PLANNING CONSULTATION REPLY

APPLICATION: 8 Norcross Gardens, Darfield, Barnsley, S73 9NY

2	0	2	2	0	7	1	0
---	---	---	---	---	---	---	---

Tree ref no. G3

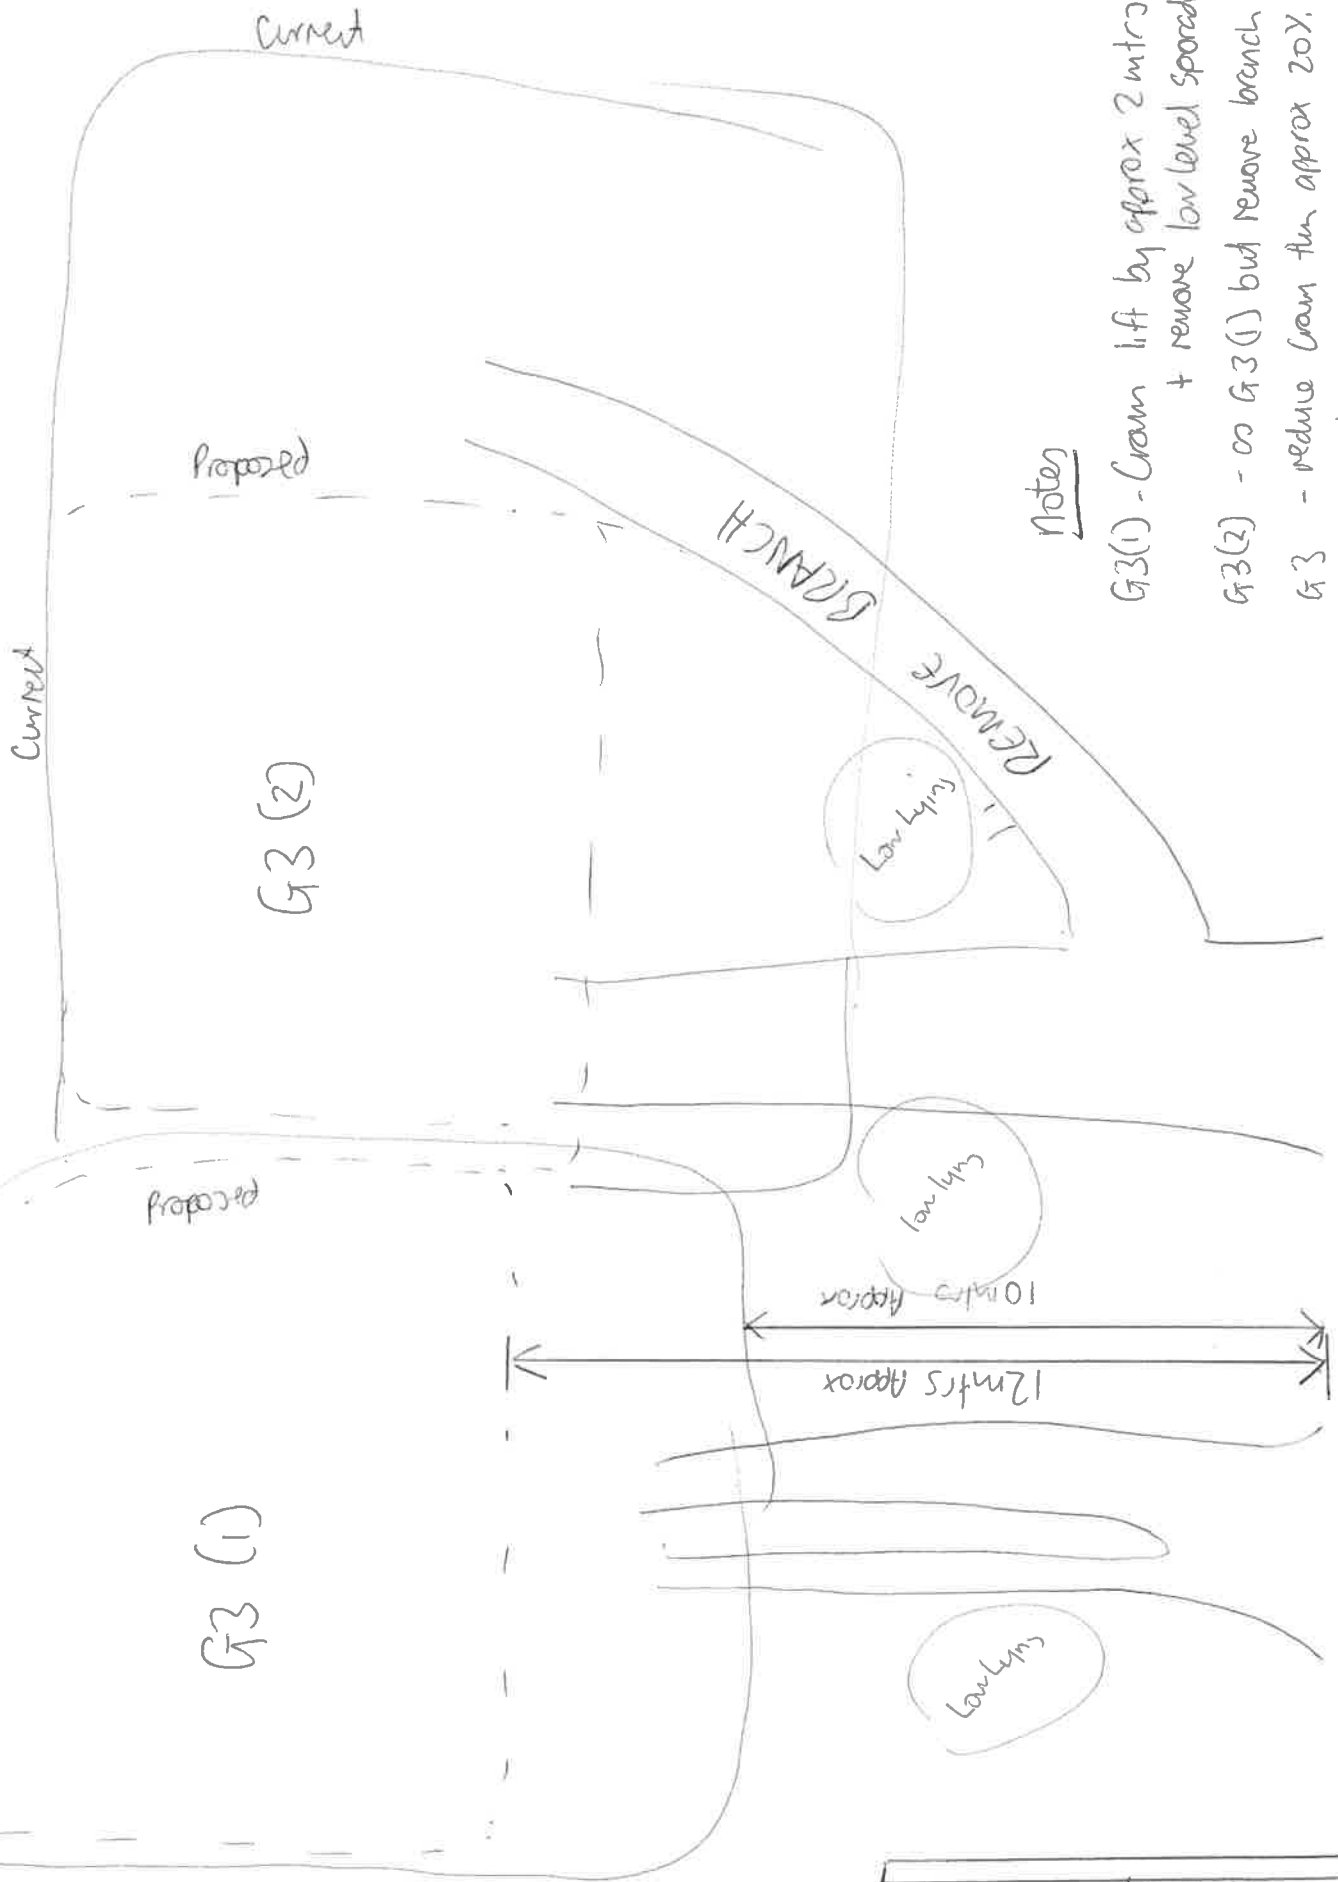
The Sycamore trees are located to the rear of the applicants property and given the open nature to the rear are prominent in the locality. There was an element of confusion over the proposed works given the works description and the photos provided with the trees marked on however, these have been clarified and the new works description is as follows crown lift trees within G3 to 4m, reduce all round to suitable pruning points by up to 1m and remove the limb marked on the photograph.

The works proposed are considered sensible maintenance and will act to remove lower hanging branches from over the garden as well as reducing the overall size slightly to allow more light around the trees. Although not considered ideal the minor reduction works in this instance (including the removal of the obstructing limb as marked) should be able to be accommodated with the assurance that the trees will be pruned back to proper pruning points to avoid the issues usually associated with crown reductions. The works will remove a significant amount of the trees leafing areas however they are still within the bounds of what can be considered acceptable.

The works proposed now are considered acceptable and as such there is no objection from an arboricultural perspective.
